CPRE Sussex
Brownings Farm
Blackboys
East Sussex TN22 5HG

3rd March 2021

P/97/20/PL Residential development of 36 No. dwellings (net increase of 15 over current consent P/70/19/RES) including affordable housing (additional 5 units) with associated access, parking & landscaping. Land To North Of Summer Lane Pagham PO21 4NG

Drawing Title
Proposed Site Plan
105 Unit Scheme

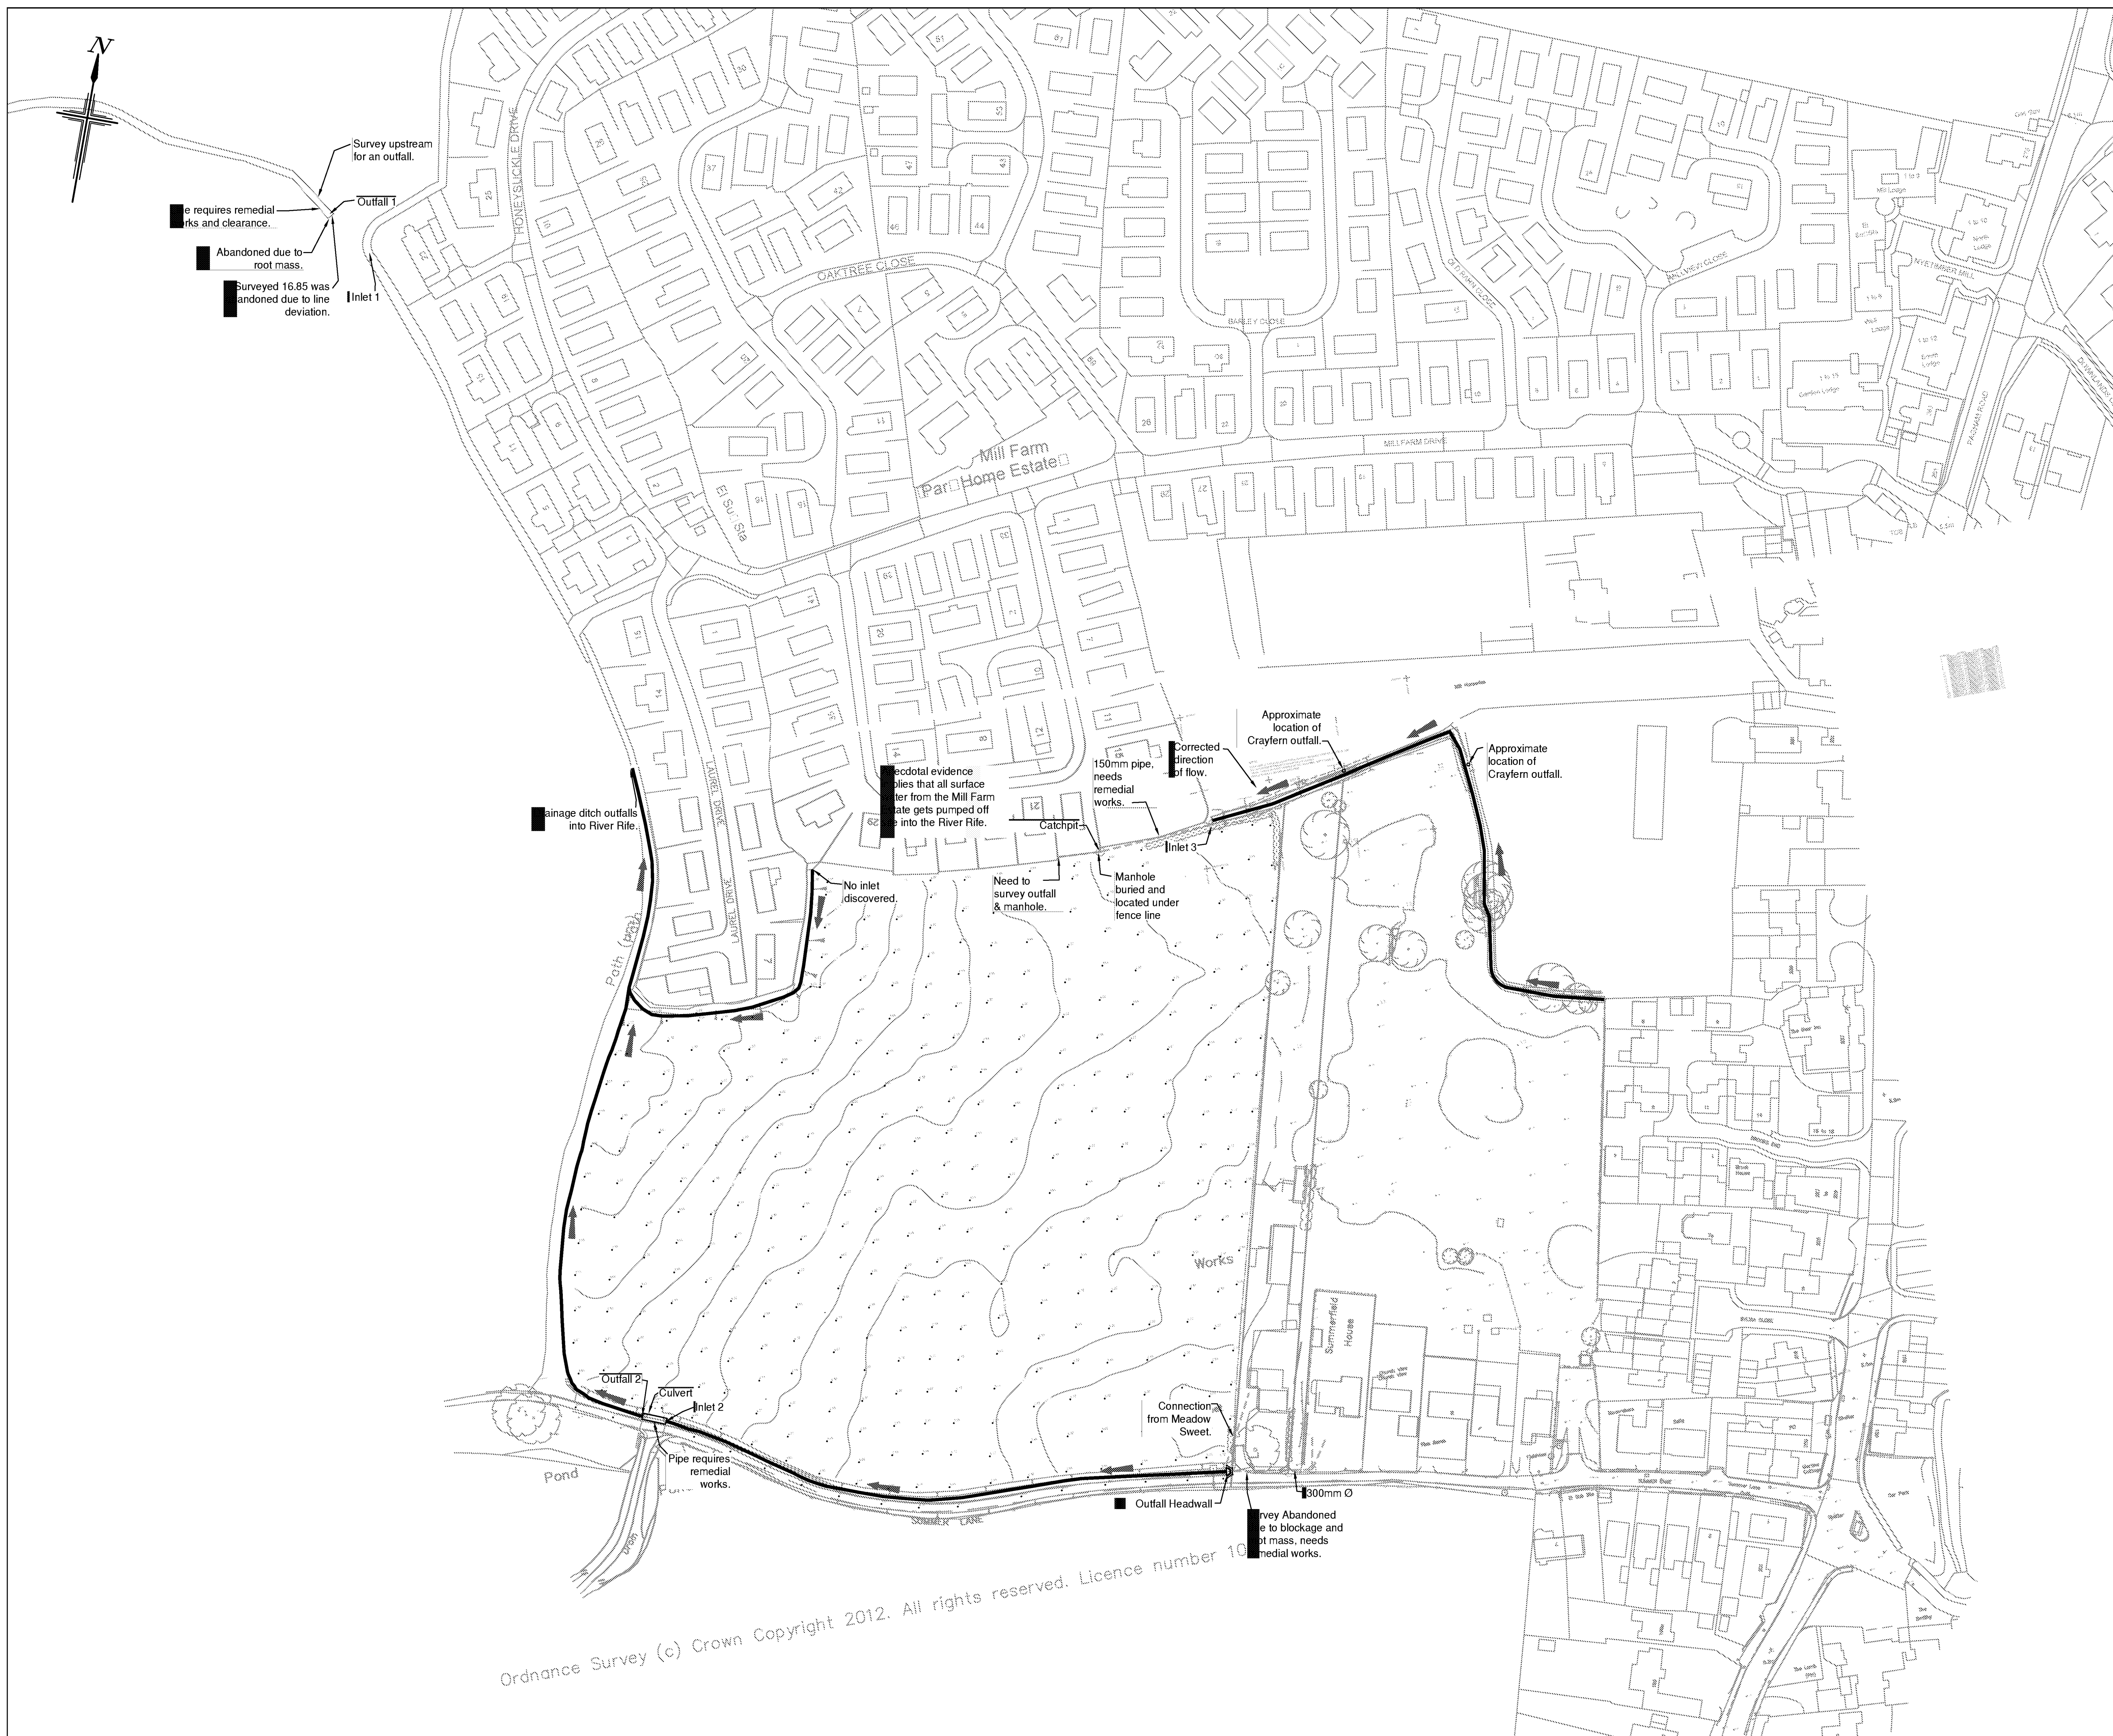
The plans below demonstrate that the approved plans have more generous plot sizes and gardens and appear less cramped than the dwellings now proposed. The dwellings approved along Summer Lane are set well back from the road with landscaping along an open ditch in front of them to reflect its rural edge location. In contrast the dwellings now proposed present a more urban appearance with only private front gardens separating them from Summer Lane. The ditch has been culverted (against WSCC policy) which as well as increasing flood risk when the culverts get blocked, will reduce the rural green aspect to this lane.

The main street accessing the whole development is shown on the approved layout as lined with eight street trees to soften the impact of front of plot parking. In the proposed layout two of these trees have disappeared and been replaced by more parking spaces to accommodate the two additional plots which now front on to this street. As the main entrance to the site this street is of significantly poor design quality as a result of the amendments. This deterioration continues round into the western part of the site where again additional plots result in more parking spaces and less green space. Only four street trees are shown in front of plots 90, 91 and 96 compared to the 10 shown on this side of the road in the approved plans.

The layout to the east of the access feels much more dense compared to the approved plans with less space left between dwellings and for greenery along the streets. Plot 53 in the approved layout, a large detached dwelling with street trees in front of it and generous space around it and the turning head, has been replaced by five dwellings (plots 55-59) on the new layout. These cramped dwellings have minimal greenspace at the front and only one street tree, dominated by parking spaces.

In conclusion, it is considered that the design quality of the proposed scheme is much poorer than the approved scheme and presents a much more urban and cramped appearance to this sensitive site on the edge of Pagham. It is therefore contrary to the Arun Local Plan Policies D SP1 and D DM1 and the Arun District Design Guide adopted as an SPD in January 2021.
